Commercial, retail and hotel tower development and associated public domain works (MP 08_0238) at 77-81 Berry Street and 88 Walker Street, North Sydney.

The Department has reviewed the submissions received and considered the proposal as detailed in the EA. The Department has identified a number of key issues with the proposal relating to Draft North Sydney LEP 2001 (Amendment 28) and height, cumulative wind impacts, cumulative traffic impacts and some design elements of the proposal. These issues are outlined in **Attachment 1**.

ATTACHMENT 1 – DEPARTMENT OF PLANNING KEY ISSUES

ATTACHMENT 2 - ADDITIONAL INFORMATION REQUIRED

Figure 49 – Proposed pedestrian bridge over Little Spring Street

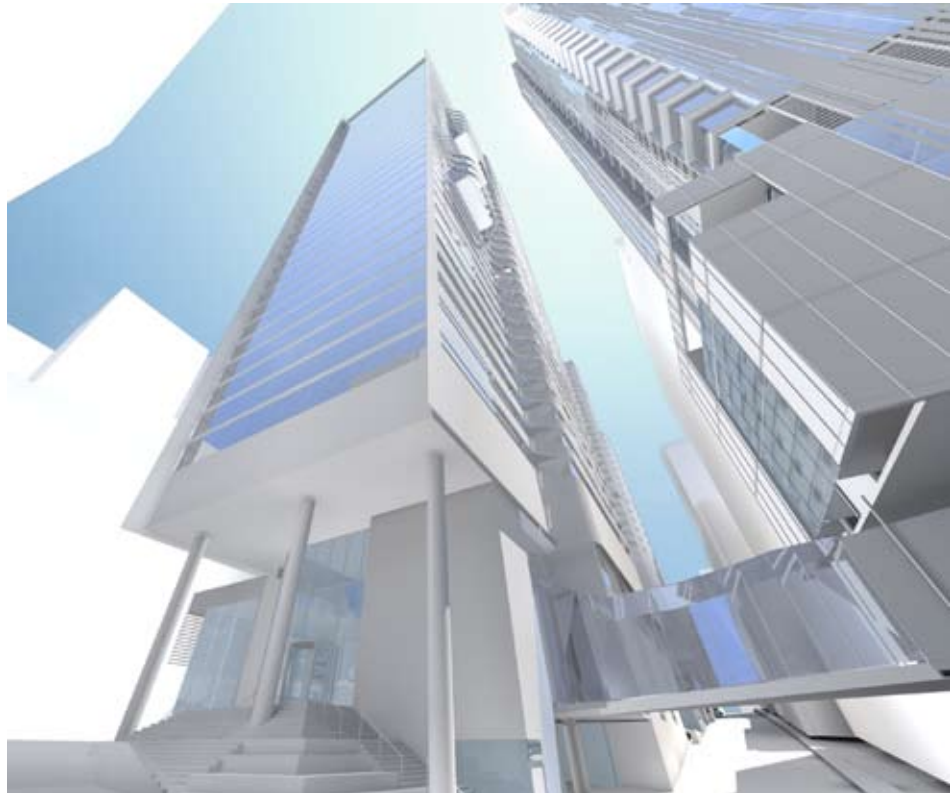
The Department has concerns with the lack of justification for the proposed pedestrian bridge and an assessment of other alternatives, including at grade access. Further analysis including different design options is required.

NEW CROSS STREET SOUTH ELEVATION

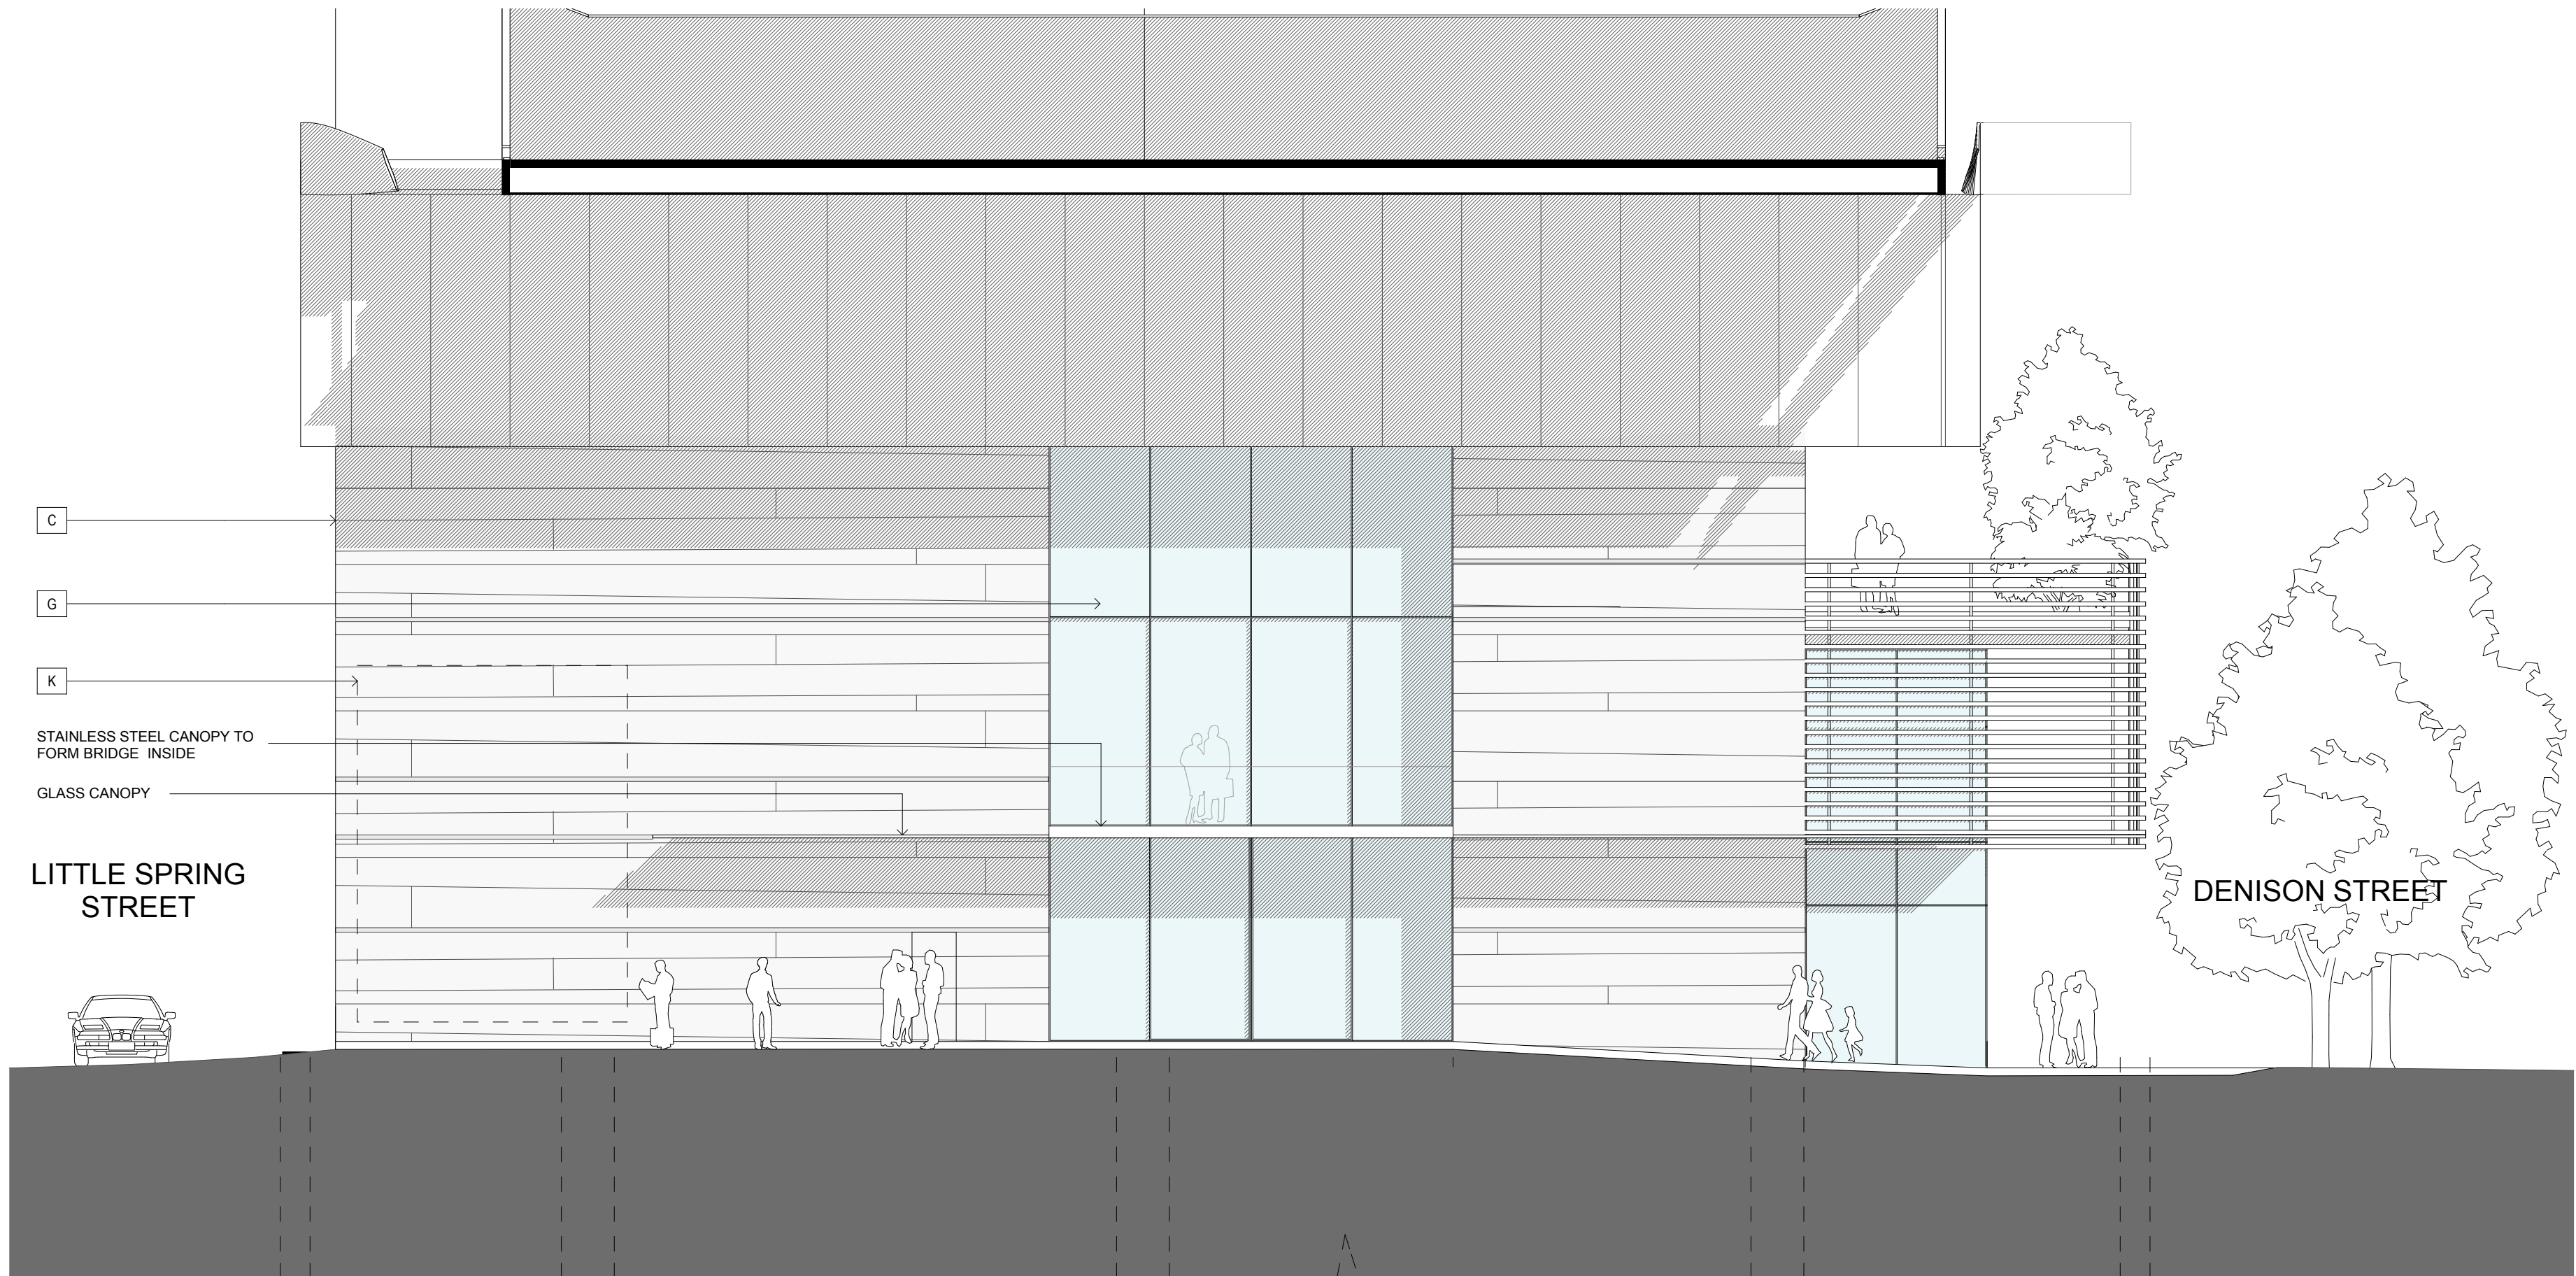
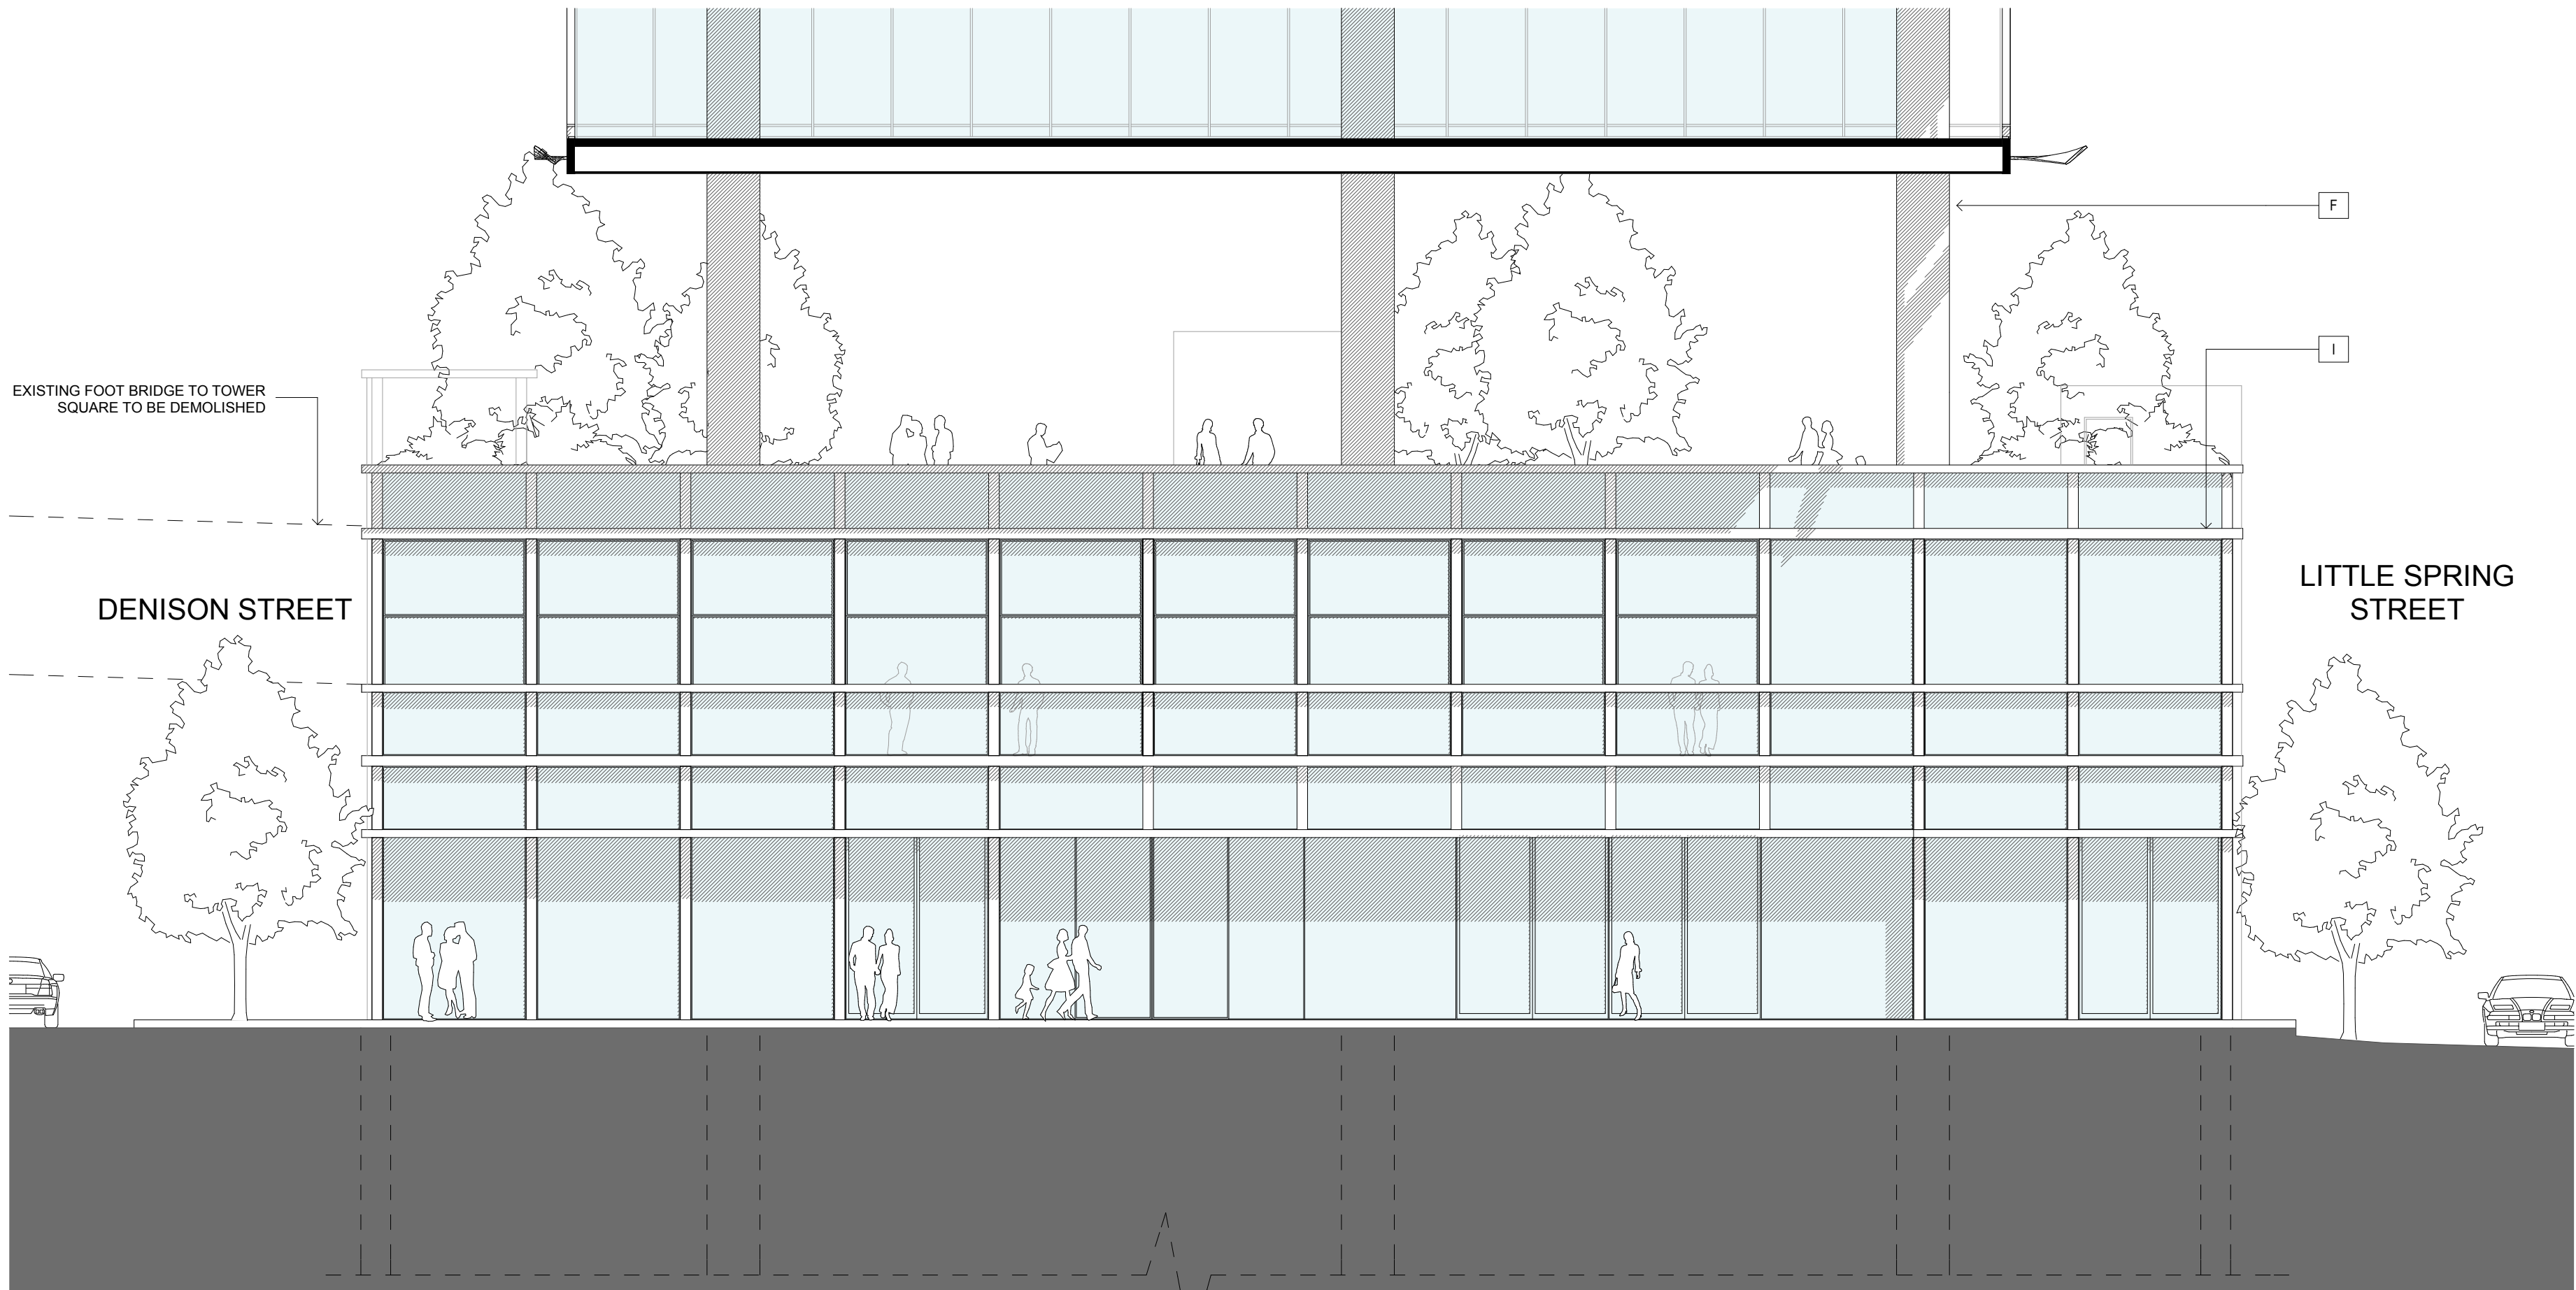
The Department has concern with the design of the internal walls and soffit to the through site link. Further design resolution is required to improve activation of elevations at ground level and to maximize penetration of natural light.
